WEST YORKSHIRE POLICE

Designing Out Crime Officer

To: Bill Topping	Ref: 2018/93201 Date: 28/01/2019
------------------	-------------------------------------

Site Location: Former St Lukes Hospital site, Blackmoorfoot Road, Huddersfield HS4 5RQ

SCALE AT: 1:500	DATE: 11.09.18	DRAWN: TS	CHECKED: --
PROJECT NO: 1835	DRAWING NO: 1835.100	REVISION: --

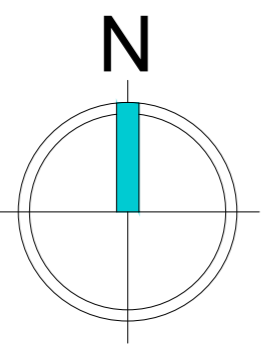
Referring to site plan drawing number 1835.100 dated 11/09/18.

The overall site layout is acceptable with good levels of natural surveillance around the properties and most of the site entrances.

However, I have concerns about the site permeability as shown on the above plan. There is a proposed footpath leading from the site onto Nabcroft Lane in the South East corner of the site. This footpath is not overlooked by any properties from within or external to the site. There would be no natural surveillance of any offender gaining entry to the site from this point by residents and they would then have full access to many of the properties around the perimeter of the development. I strongly suggest that this footpath is moved 50 metres NW up Nabcroft Lane towards Blackmoorfoot Road. This would position the entrance to the site in view of overlooking properties making it safer for site residents to use.

Plots 76 and 77 are shown as having a rear boundary wall backing onto a shared parking area in front of plots 92 – 99. Could consideration be given to making these parking bays in curtilage to the properties. This would be beneficial for vehicle security and also to minimise the potential for youth related nuisance, such as using the fence of 76 and 77 as football goals. Anti-social behaviour and neighbour disputes can often be triggered by children and youths using open areas such as this.

Further details would be required for the boundary treatments of plots 1 – 10, 112 – 118 and plots 201 – 203. I would recommend the rear boundary treatments for each plot are to a height of 1800mm such as masonry materials, close boarded timber fencing or other durable materials. Rear plot dividers in height of 1800mm consisting of the same material as above should be installed between properties.
